## DELEGATED DECISION

<b>Application Number:</b>	19/1590/OUT	<b>Grid Ref:</b>	E: 302124 N: 231200
<b>Community Council:</b>	Yscir Community	<b>Valid Date:</b>	24.10.2019
<b>Case Officer:</b>	Catherine James

**Location:** Land Adjoining 68 Degrees West Glamping Site, Cradoc, Brecon, Powys, LD3 9LP

**Proposal:** Outline application for the proposed detached utility building to service existing campsite (for provision of office/reception, secure storage of grounds maintenance machinery, maintenance equipment, indoor games room, WC, Laundry and kitchen

North West Elevation

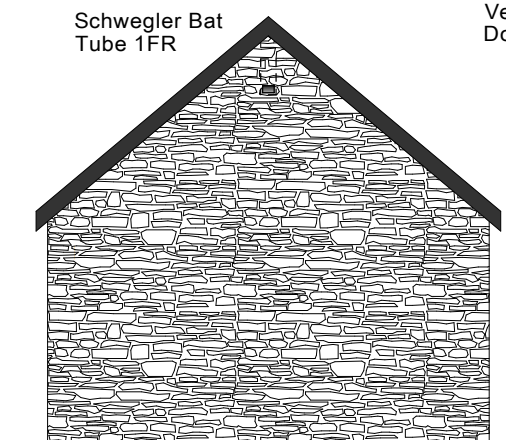
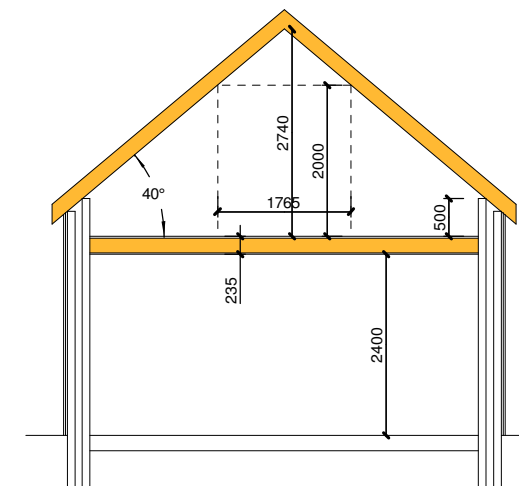
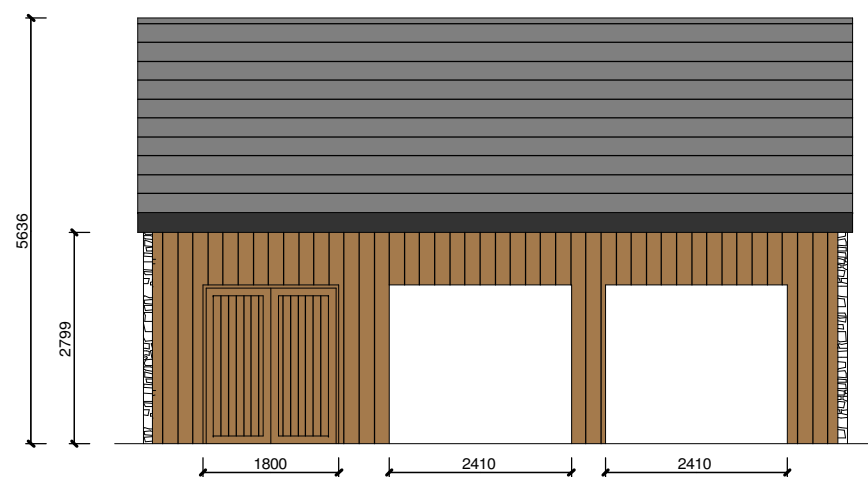
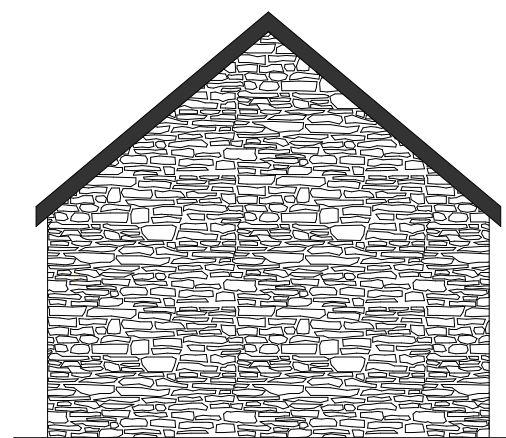
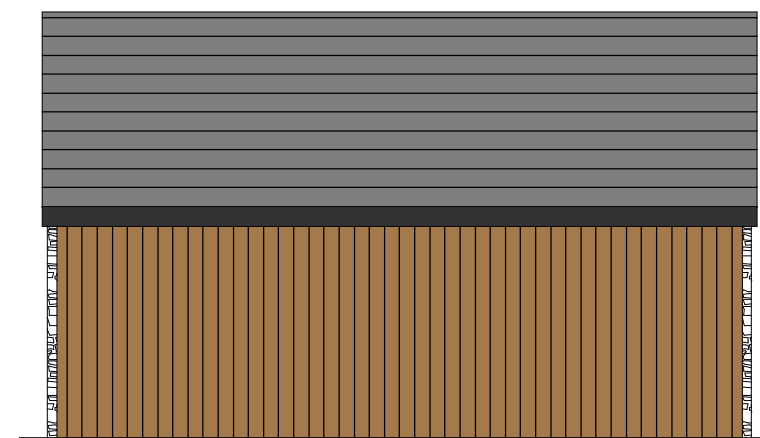
- Existing Site Layout (Drawing: 1437/S/01 Rev C) (shows 5 caravan pitches, 10 tent pitches, 12 log pods and shower block on the site). No hot tubs are shown on the existing plan. Proposed elevations (Drawing: 1437/PLN/002 Rev I) (shows details of the utility building) Proposed site layout/ecology and biodiversity enhancement (Drawing: 1437/PLN/003 Rev I) (shows parameters for the managers cottage as well full details of the reception building)
- Proposed house type & utility barn (Drawing: 1437/PLN/001 Rev I) (shows elevations and footprint of utility building)

The proposed building is approximately 12.6m long and 10.4m wide aligned north/south on the site at the eastern end. It is proposed to be a two storey building and will measure 3.9m to the eaves and 7.9m to the ridge of a double pitch roof. The building will be timber clad with some stone and render under a slate roof to reflect the existing shower/toilet building currently on site. It is acknowledged that the proposed building is relatively large compared to the existing building but the space is required to accommodate machinery storage and staff facilities. The building will be prominent on the site but this can be mitigated with appropriate landscaping. To protect the building as a utility building for functional purposes supporting the business and to prevent the inappropriate development of residential development in the open countryside it is recommended that an appropriate condition be attached restricting its use.
